Planning Application Ref: A/150/19/DOC

Location: Land to East of New Place Bungalow, Arundel Road, Angmering, BN16 4ET

Description of works: Approval of details reserved by condition imposed under ref A/131/16/OUT relating to Condition No 10 - hedge/tree retention & protection

Drawing Title	
Detailed Tree Protection Plan	
Client	Date
GD Group	22.10.19
Project	Drawing Ref
Arundel Road, Angmering	DTPP
Scale	Job Number
1:250@A2	1911
Drawn	
JLD	
The Urban Forest Consultancy	
W www.ufc.co.uk E joerning@ufc.co.uk M 07568021537

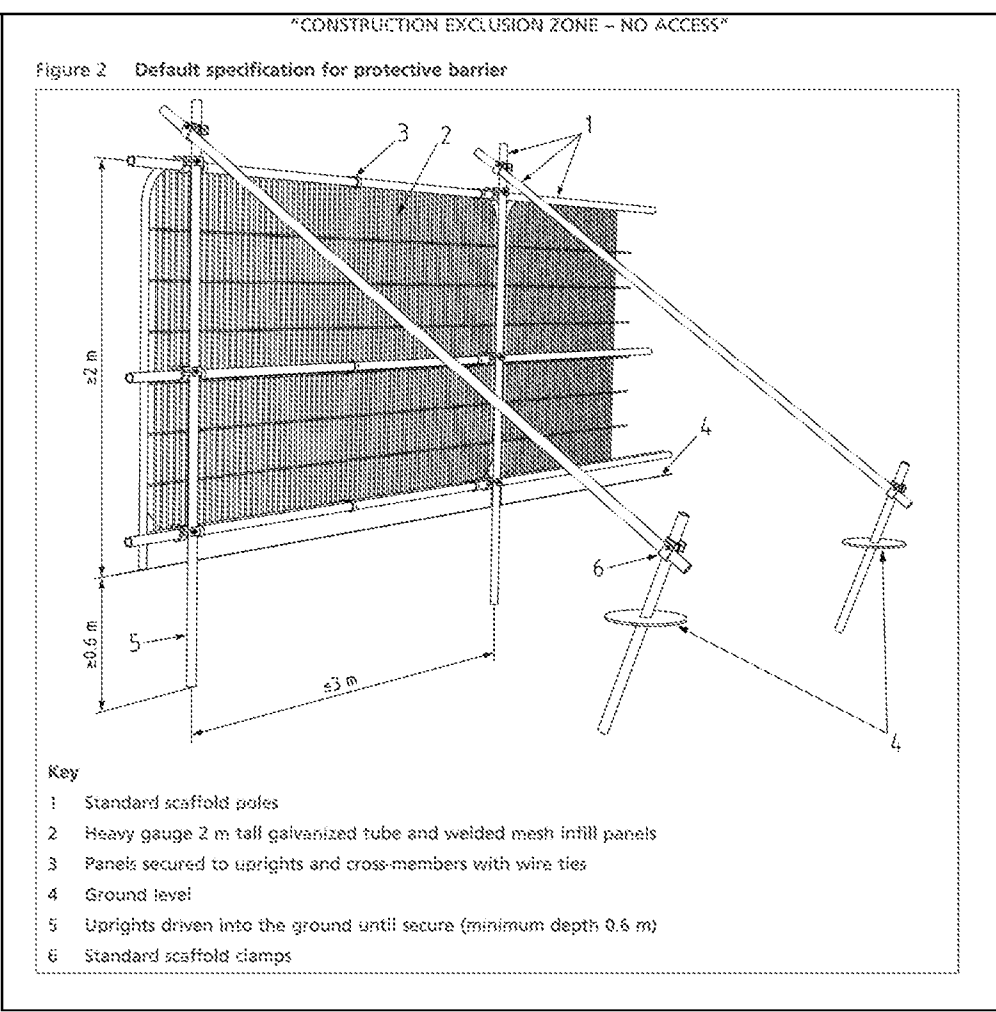
- I re-visited site on the morning of 21st January 2020, with Mr J. Elsey of GD Group in attendance. Vegetation clearance, facilitation pruning and groundworks have begun, and the access road has been constructed. I was able to access all areas of the site where tree protection was installed. I was in possession of approved **Tree Protection Plan** from **Urban Tree Consultancy, dwg. ref. DTPP, dated 22nd October 2019, Rev E.**
- The vast majority of tree protective fencing was seen to be 'fit for purpose' and in accordance with the approved plan.

- The few minor exceptions and anomalies I observed at the time of my original inspection have been resolved to my satisfaction.

- I recommend we now discharge condition 10.
